SITE 3 (STAGES 2 & 3)

SYDNEY OLYMPIC PARK

REPONSE TO SOPA COMPLIANCE COMMENTS

16.09.2011

Storage Provision
2.5m3 + 1.44m3 + 1.44m3
=5.4m3

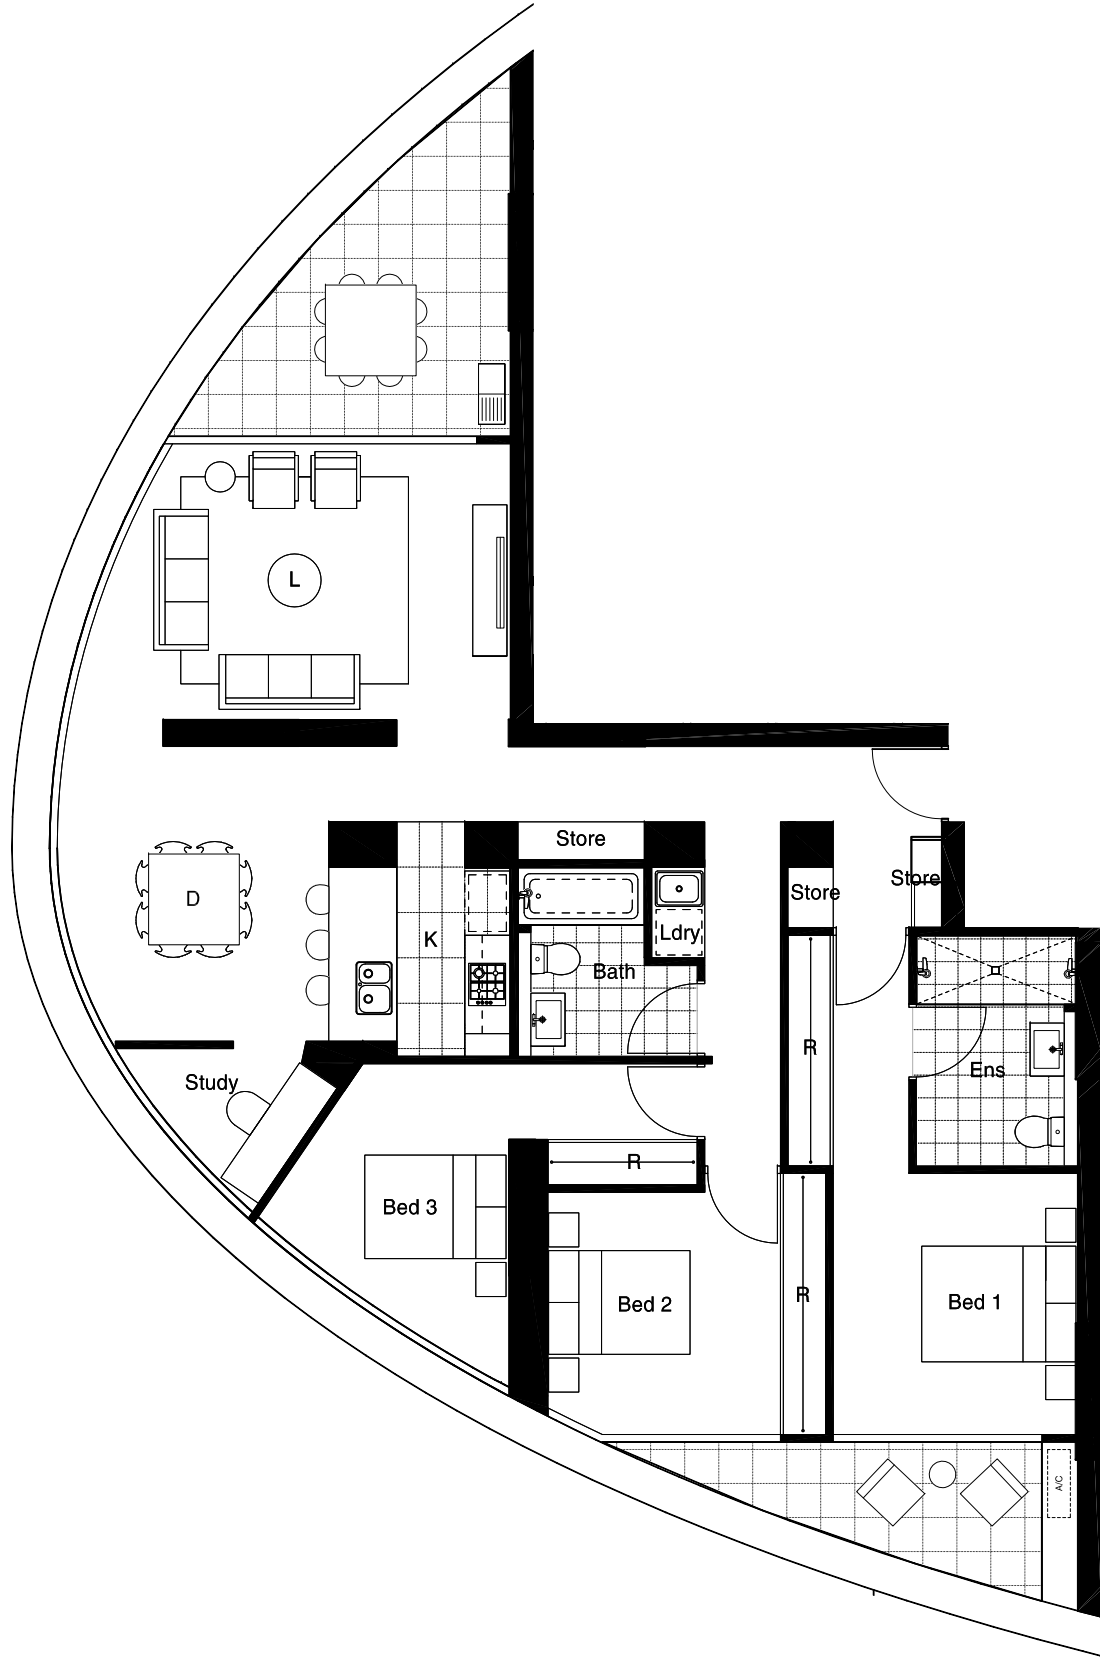
Point 29 - Storage Provision

Tower 1			
	Apartment Type			
	1 Bed	2 Bed	3 Bed	4 Bed
Storage Required by RFDC (m ³)	6	8	10	10
Number of Apartments	95	132	27	13
Total Storage Requirement (m ³)	570	1056	270	130
Tower 1 Total Storage Requirement (m³)				2026

Tower 2			
	Apartment Type			
	1 Bed	2 Bed	3 Bed	4 Bed
Storage Required by RFDC (m ³)	6	8	10	10
Number of Apartments	120	164	31	6
Total Storage Requirement (m ³)	720	1312	310	60
Tower 2 Total Storage Requirement (m³)				2402

Total Storage Requirement	
	Area (m ³)
Total Storage Requirement (m ³)	4428
50% Provision in Basement (m ³)	2214
50% Provision in Apartments (m ³)	2214

Basement Storage Provision	
	Area (m ³)
Ground	502
Basement 001	352
Basement 002	436
Basement 003	444
Basement 004	482
Total	2216

Figure 5. Tower separation analysis diagram Tower 1 to 2
Prepared by Bates Smart.

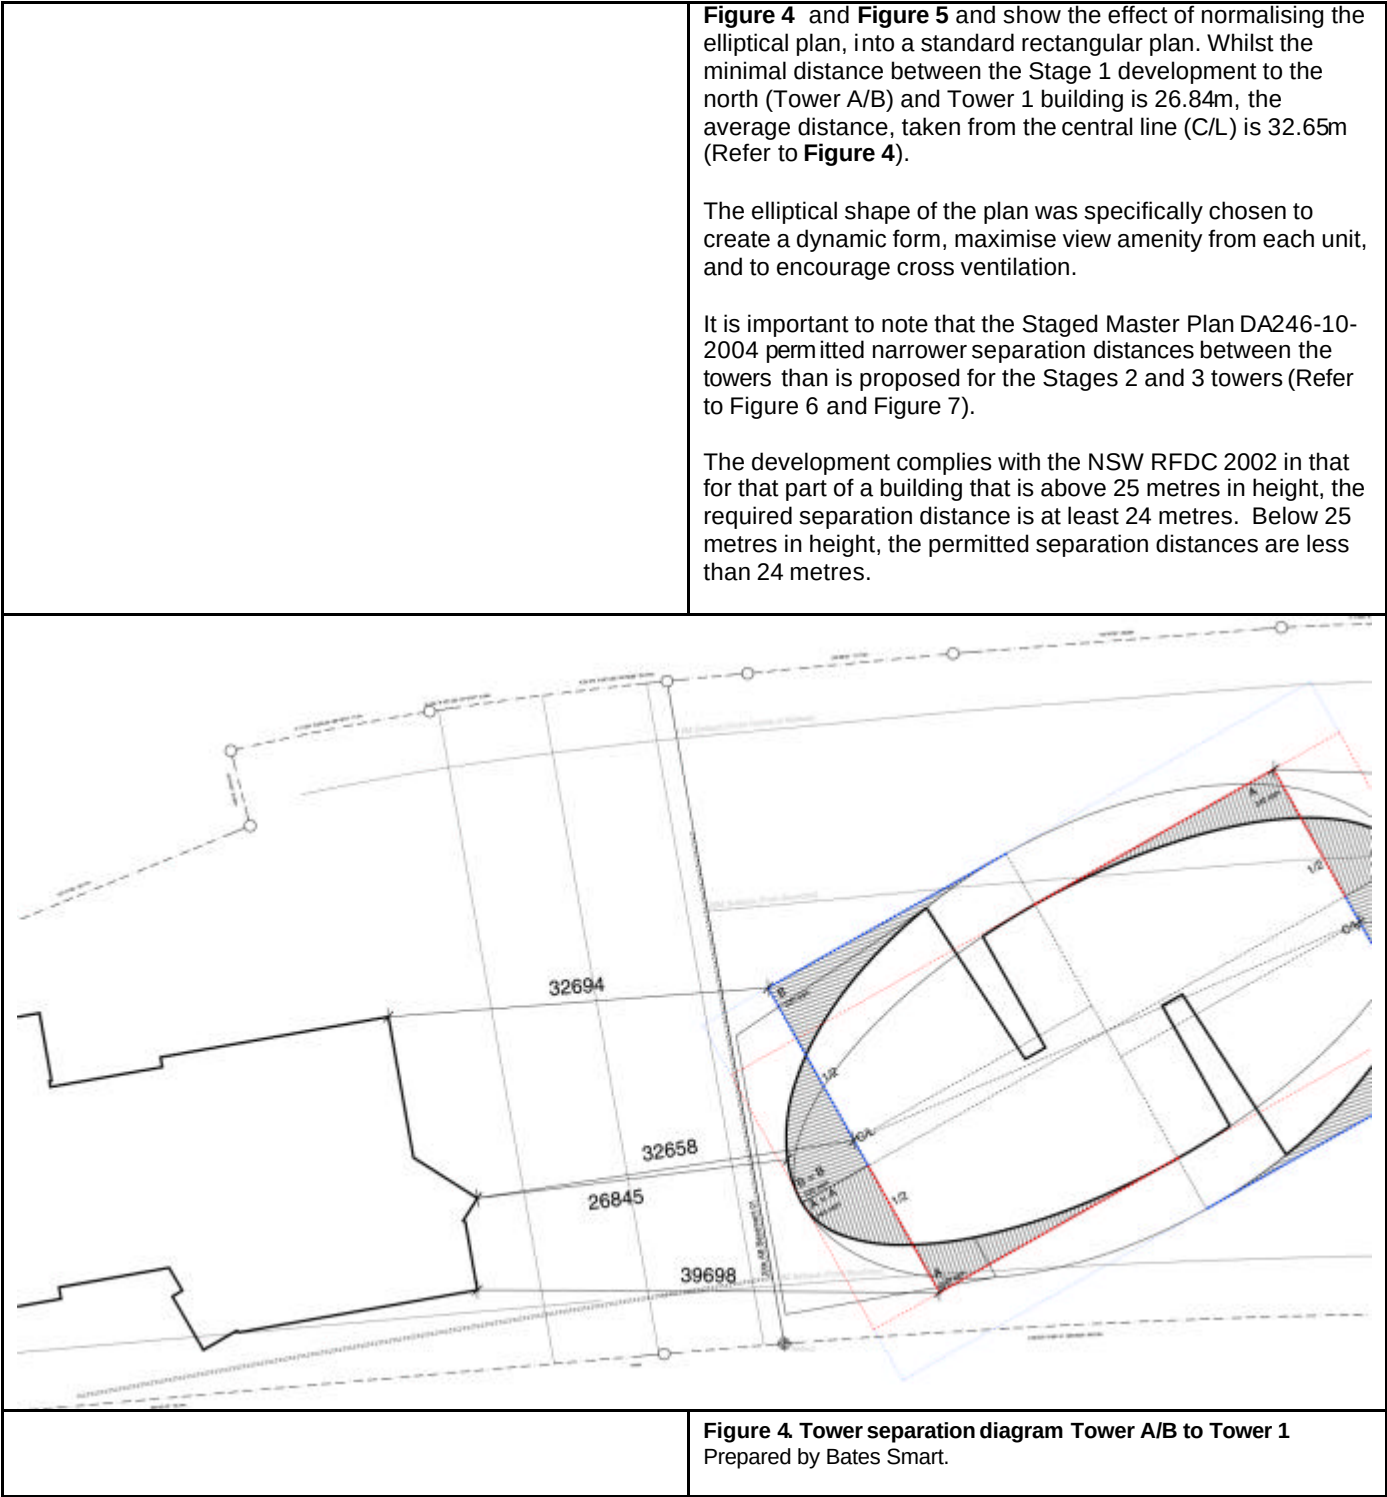
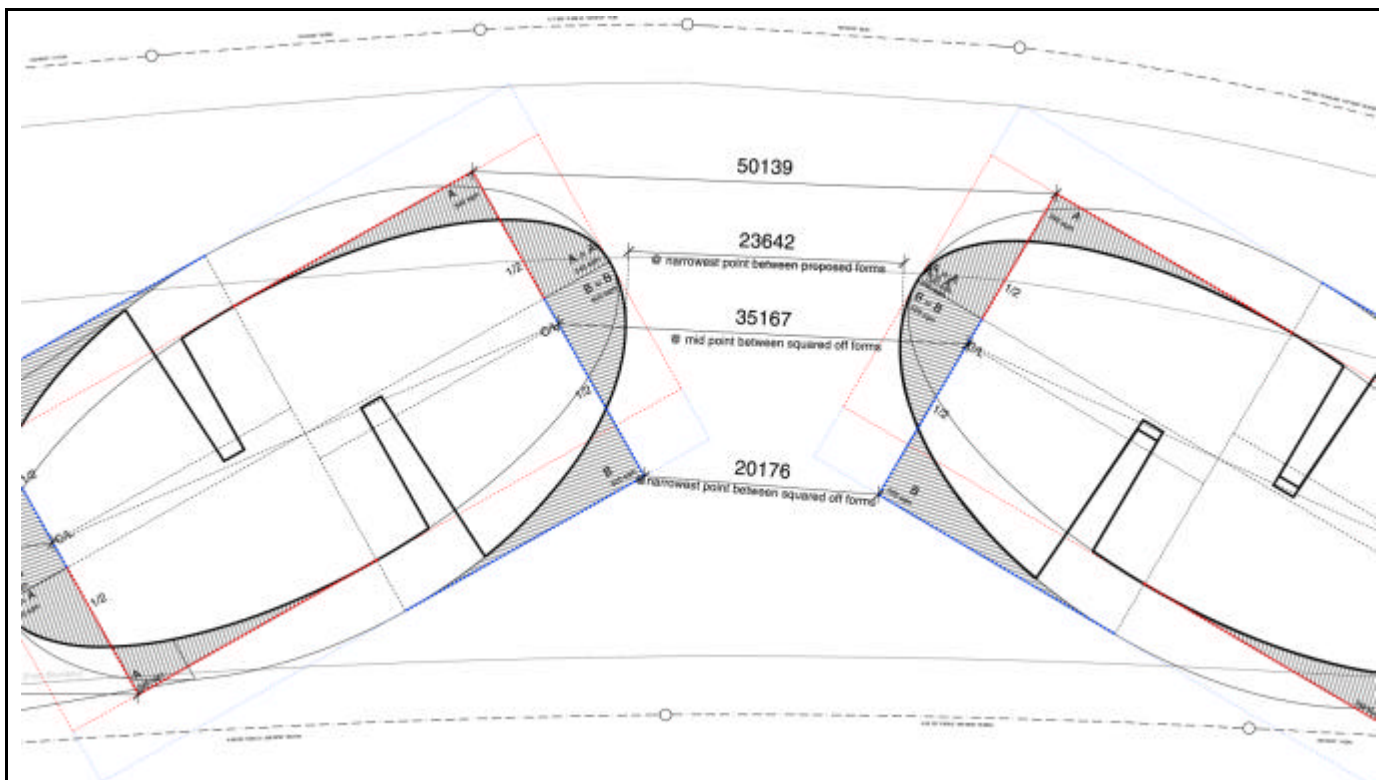
Point 11 - Compliance with MP 2030 Building Separation

The diagram to the right shows the effect of normalising the elliptical plan, into a standard rectangular plan for Stages 2 + 3. Whilst the minimal distance between the two buildings is 23642mm, the average distance, taken from the C/L of the squared off forms is 35167mm.

A 40m setback is proposed in MP2030 is to prevent overlooking between facing buildings. The towers proposed in Stages 2 + 3 are orientated on a north-south axis and are angled away from each other, meaning the living spaces in the apartments are orientated away from the neighbouring building.

Further, the proposed scheme complys with the Residential Flat Design Code which recommends a 24m building separation between habitable rooms/balconies for buildings above 9 storeys/ over 25m.

Figure 26: Privacy treatments along the vertical slots

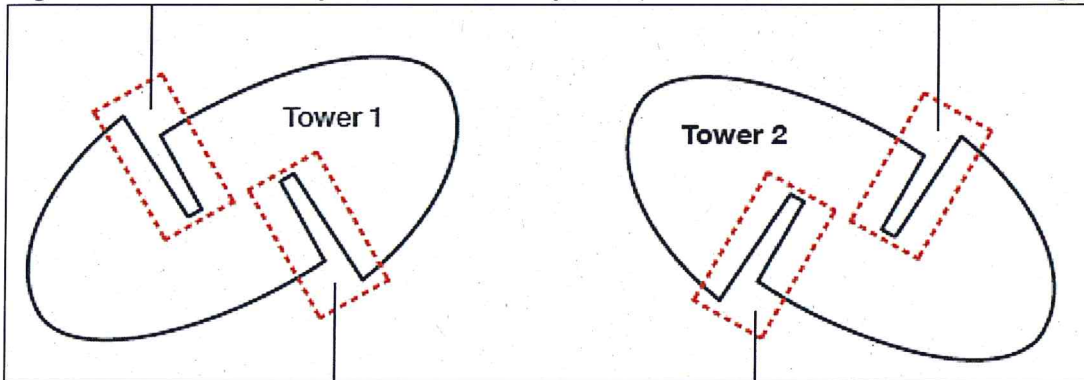
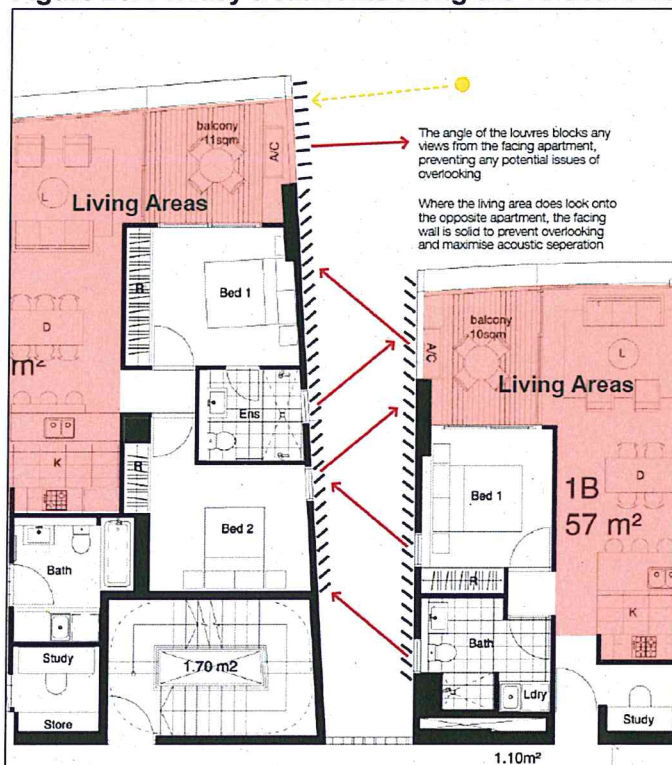
Point 18 - Configuration of the vertical slots

The vertical slots are intended to maximise natural ventilation across the development, whilst enhancing the amenity to the common corridors. Potential issues with privacy and overlooking between facing units is counteracted by the use of angled vertical louvers.

All living spaces (kitchen, dining room and living room) have been placed away from slot to maximise the distance between the most habitable rooms. The only rooms facing onto the slot are bedrooms and bathrooms, including ensuites, meaning the main living spaces benefit from the maximum amount of privacy. The windows looking out of the rooms facing the slot are staggered to maximise the sense of separation.

Staggering the openings, and using angled vertical louvres to direct the views out, ensures that no window facing into the slot will have a view into any rooms in the opposite apartment. The louvres are angled away from the building to encourage the penetration of natural daylight into the rooms. The diagrams shown above, and on the following page, illustrate the potential field of view from each window facing onto the slot. In each case, the view is directed by the louvres, which also block any view into the room, preventing any potential overlooking.
